Our Ref: WA/94/17/HH

**Town & Country Planning Act 1990 (as amended)
Town & country Planning (Development Management Procedure) (England) Order 2015
Application for Planning Permission for Works or Extension to a Dwelling**

Development Side extension & garage conversion, new dormers to front and rear elevations, 3 No. roof lights to side elevations, 2 No. solar panels to side elevation & 1 No. new window to front elevation.

Location Byways West Walberton Lane Walberton

BLOCK PLAN (1:500)

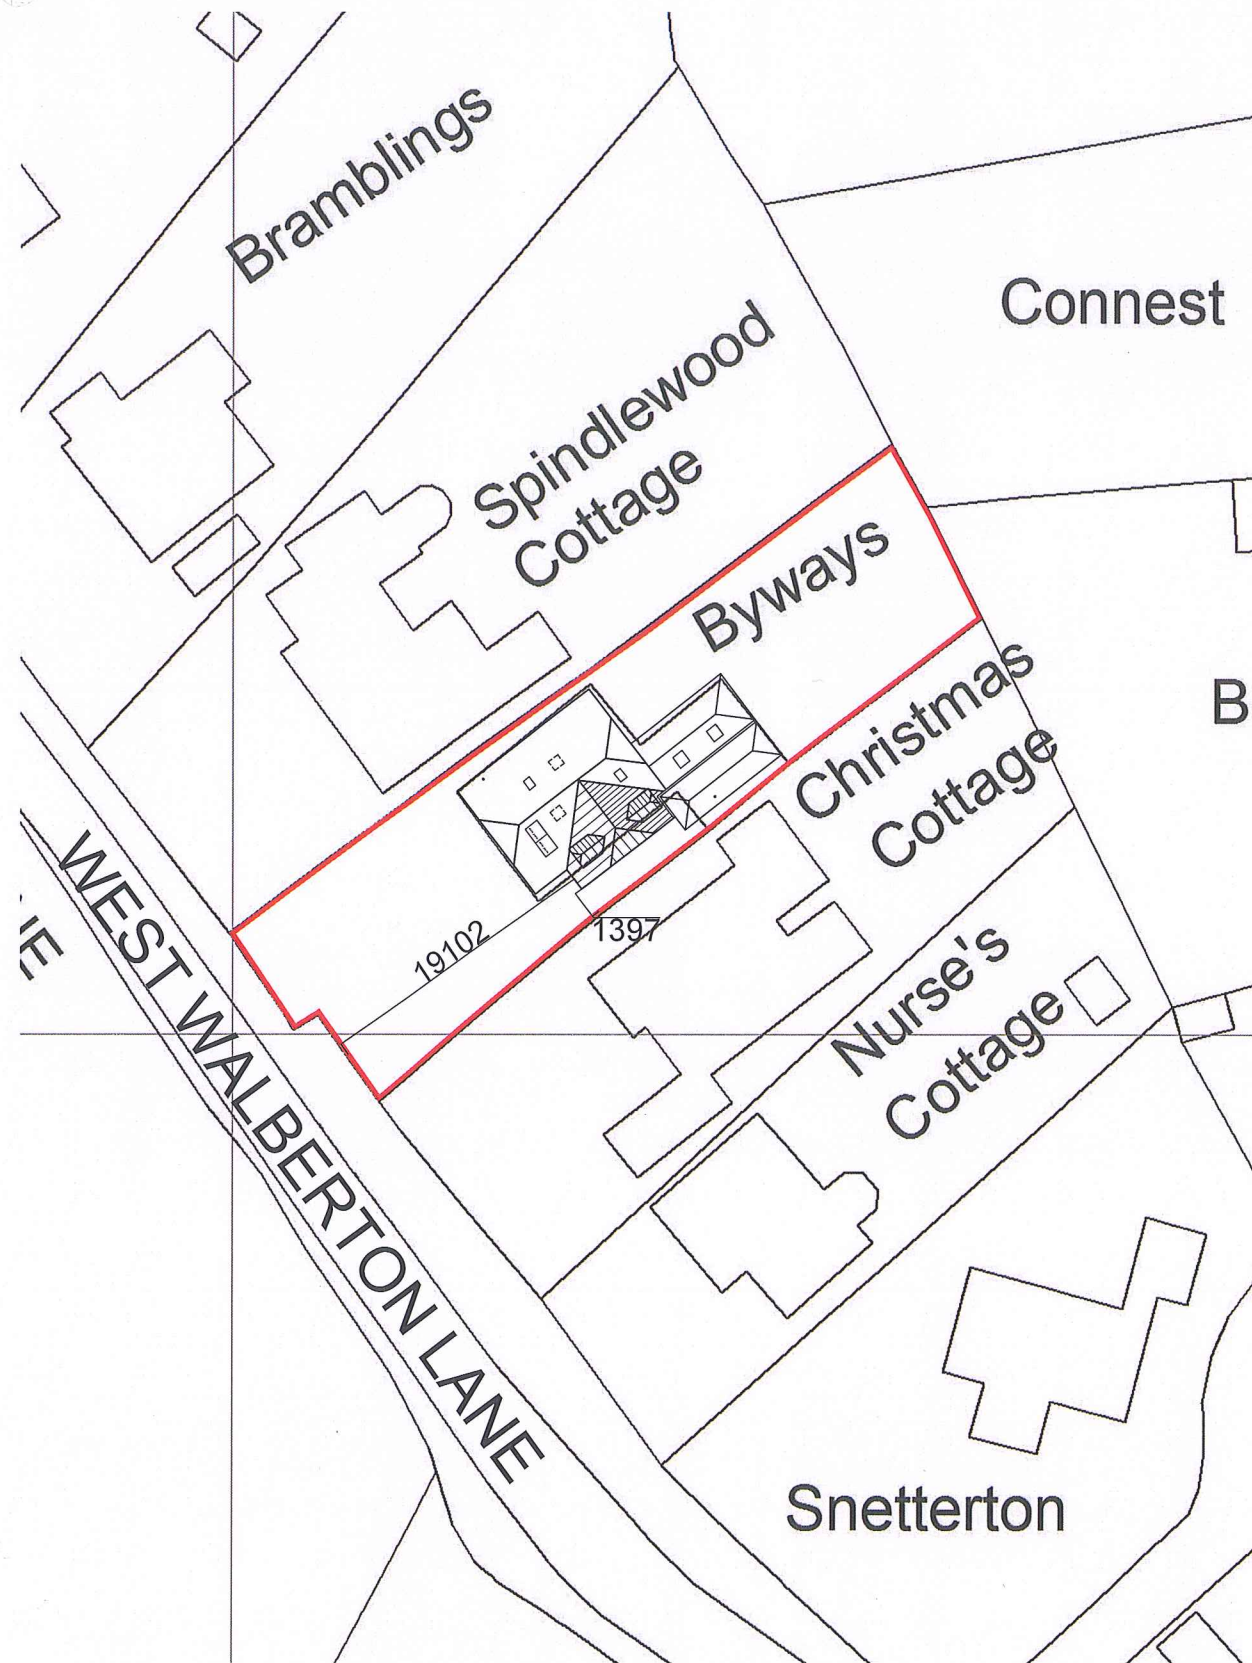
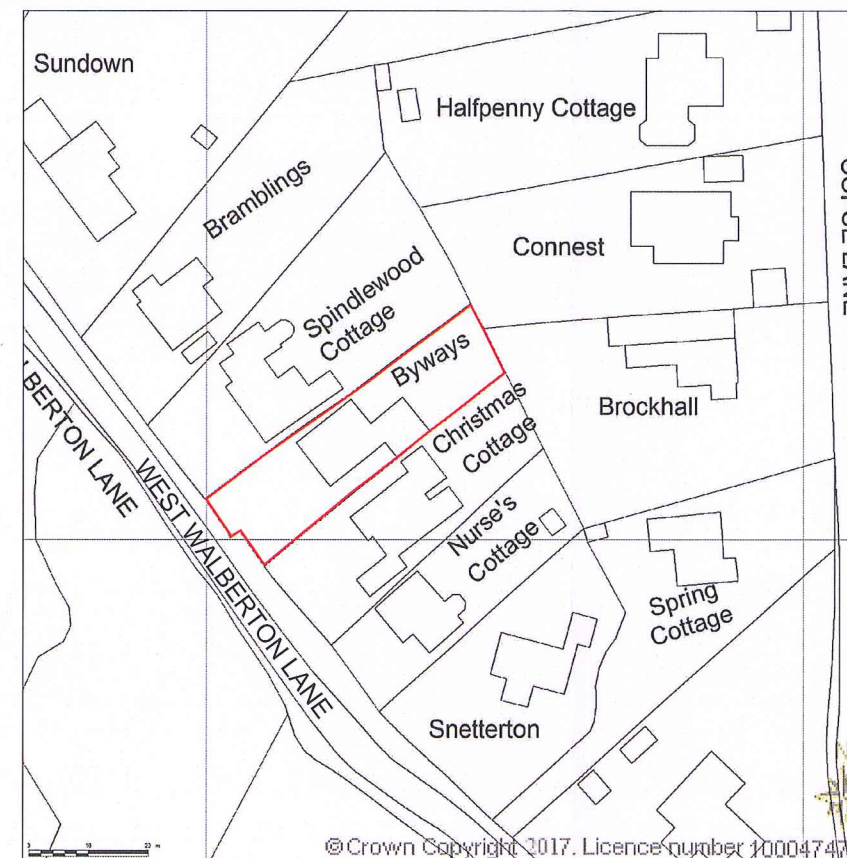
Block Plan

Please submit 1 electronic or 3 paper copies of a block/site plan at a scale of 1:500 or 1:200. Further details of what must be included on the plan can be found in the National Validation Requirements. Please highlight the proposed works.
